Recommendation Report for Works to Tree(s) on trees subject to a Tree Preservation Order (TPO)

REF NO: AW/171/18/T

LOCATION: 6 Seacourt Close
Aldwick
PO21 4RD

PROPOSAL: 3m Crown Reduction to 1No. Oak tree

OAK
TREE

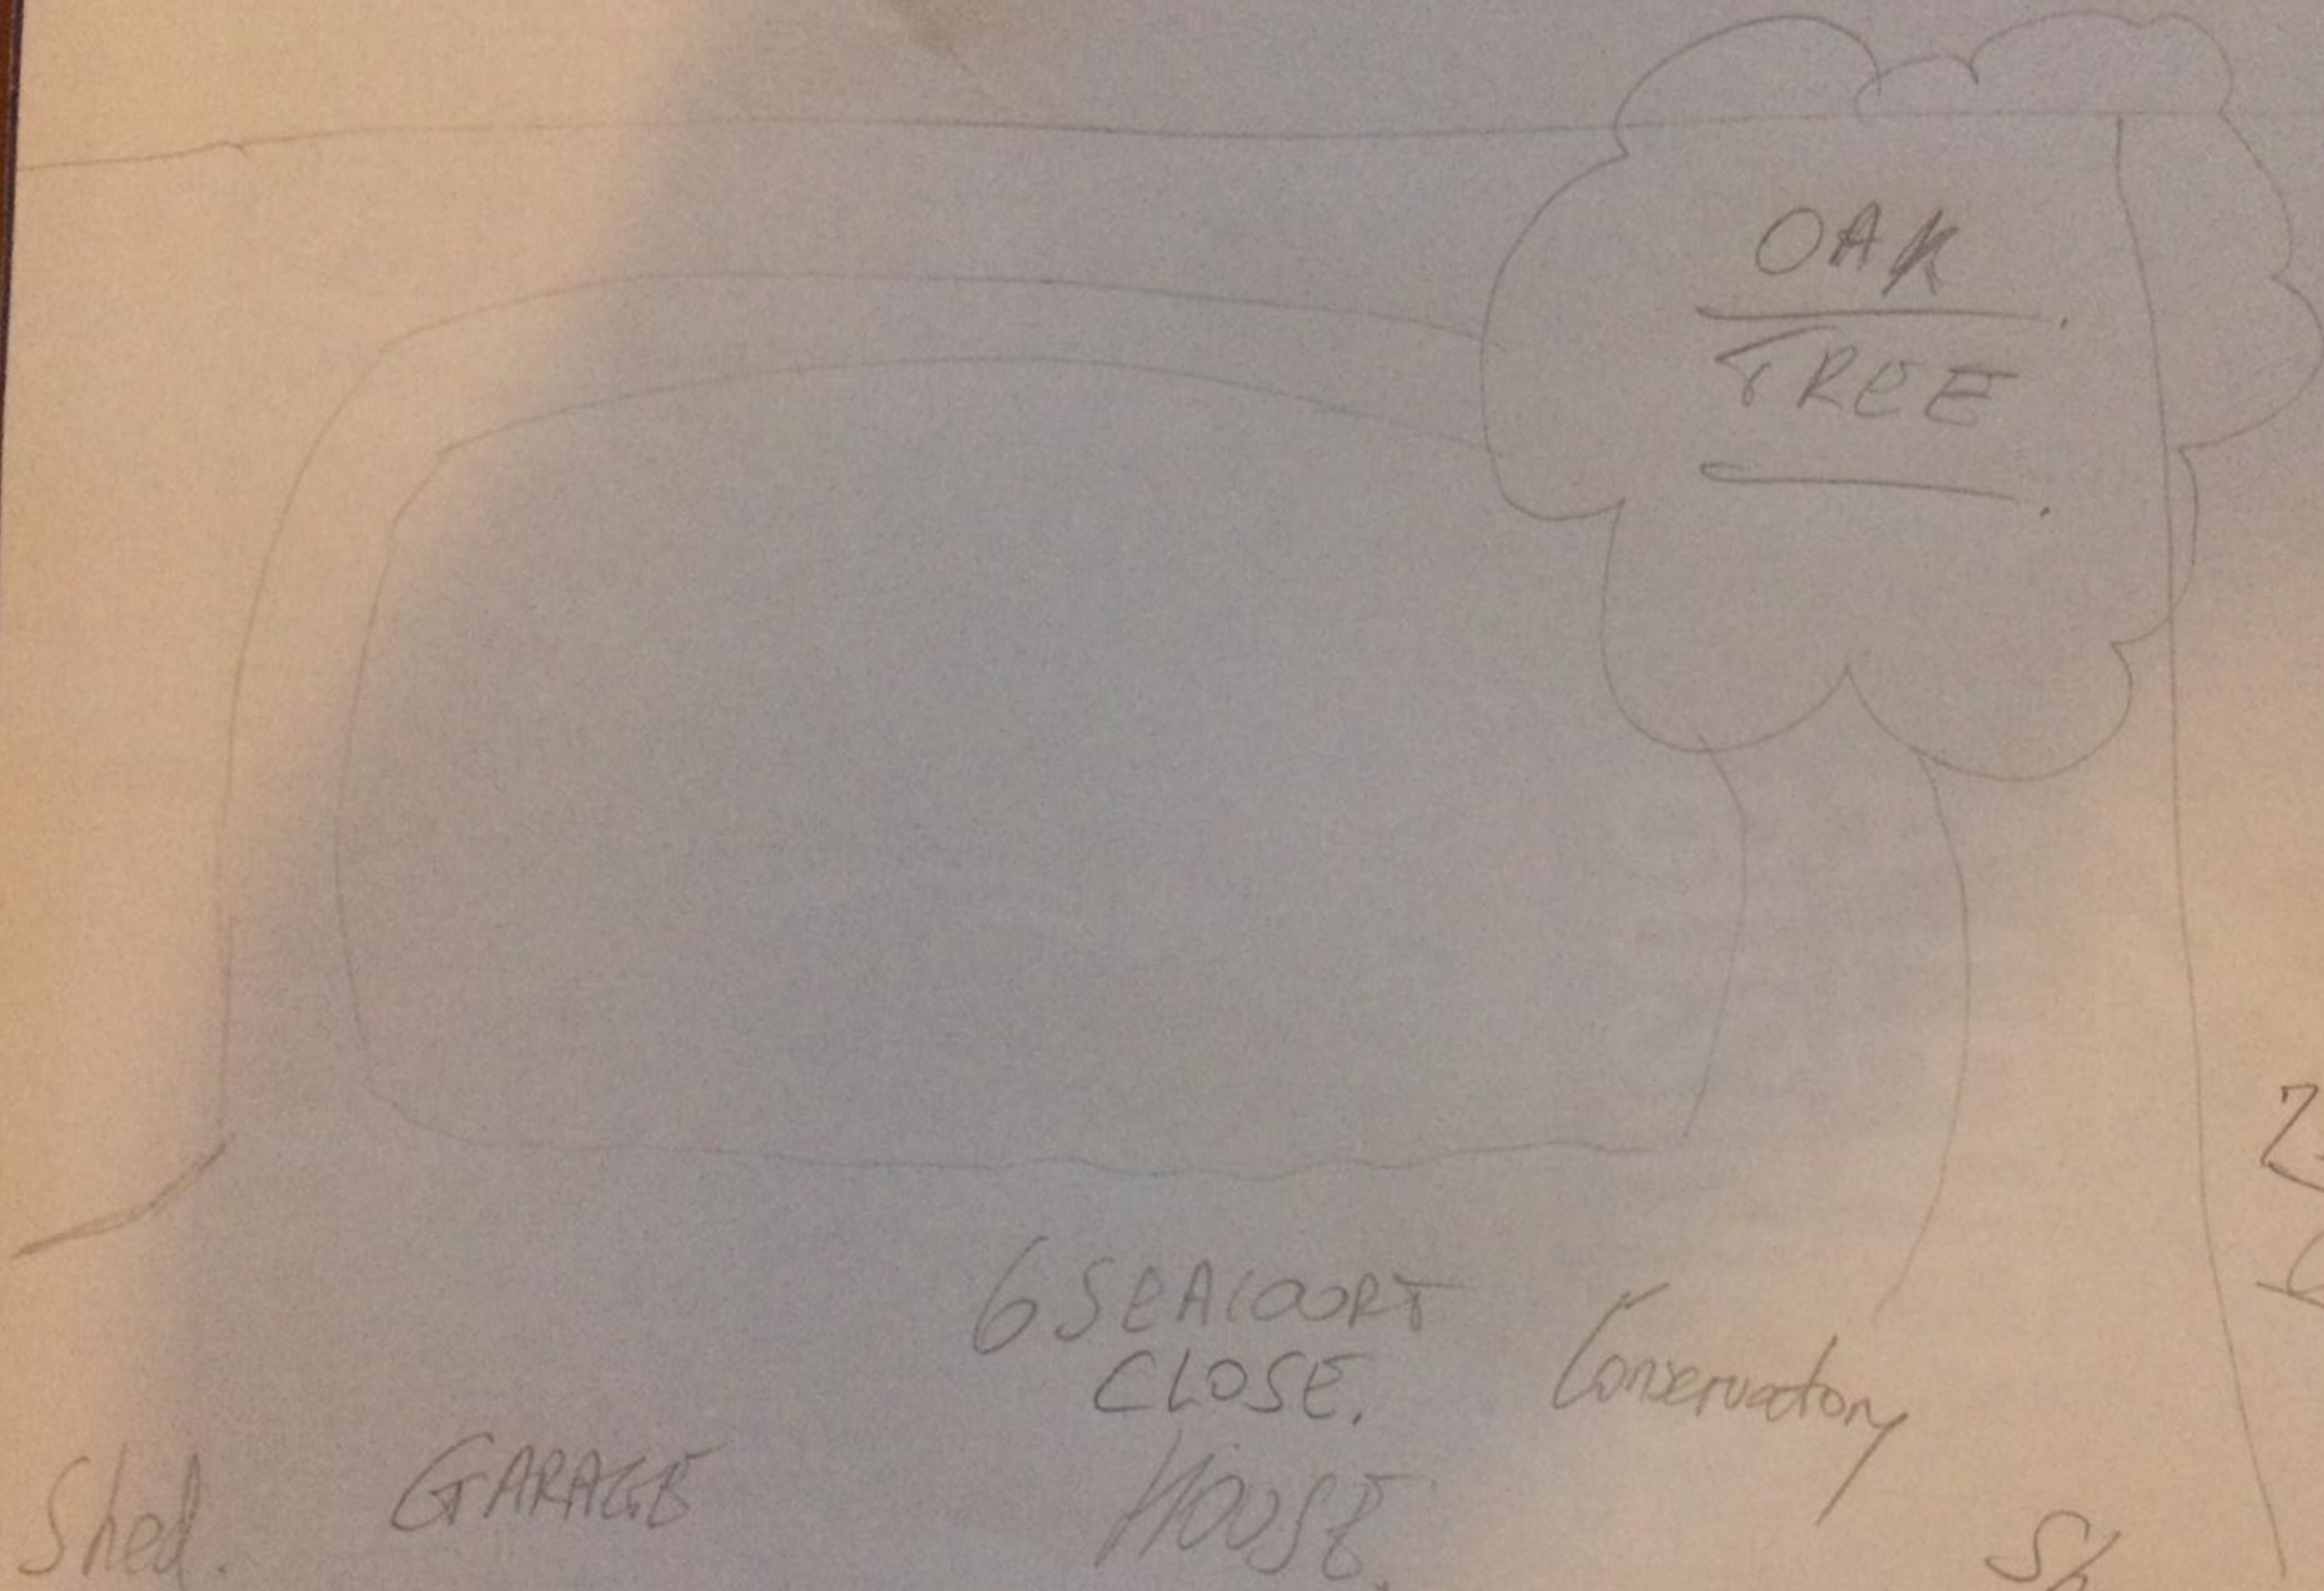
·Tree appears to be in a fine physiological state with no obvious signs of disease, when assessed from ground level. It has only moderate form at present having historically been subjected to severe crown reduction work from which it has responded surprisingly well. Although some of the primary scaffold limbs have declined there is sufficient limb framework and canopy for it to display an attractive crown

·It grows adjacent a boundary at the confluence of four rear gardens and enjoys a prominence on all aspects. It therefore is clearly visible from several surrounding properties and at a satisfactory distance from residential dwelling so as not to present unreasonable nuisance or excessive shading. It can also be seen from the adjacent publicly accessible road/footway network, albeit with some limitation - this will improve if the tree is allowed to gain in stature.

·The nearest point of built structure is a conservatory along the rear elevation of 6 Seacourt Close, at a distance of approximately 10metres from the tree.

·The extent of pruning work proposed exceeds the requirements of British Standard 3998:2010 'Tree Work' - Recommendations.

·It has not been demonstrated (nor evidence provided in support of) that this tree requires crown reduction work on arboricultural grounds. I see no obvious risk of damage to built structures at this time. Although the boundary fence lines are in varying states of disrepair they are both intact and functional with scope to accommodate main stem expansion as the tree grows.

·The tree already represents a visual amenity and has potential to develop into a significant feature in the local landscape. It appears to be in adequately sound and healthy condition. The tree surgery proposed in the application would result in excessive reduction of the tree's current value and curtail its potential, thereby constituting an undue detriment to the visual amenities of the locality.

·I recommend REFUSAL for this application.
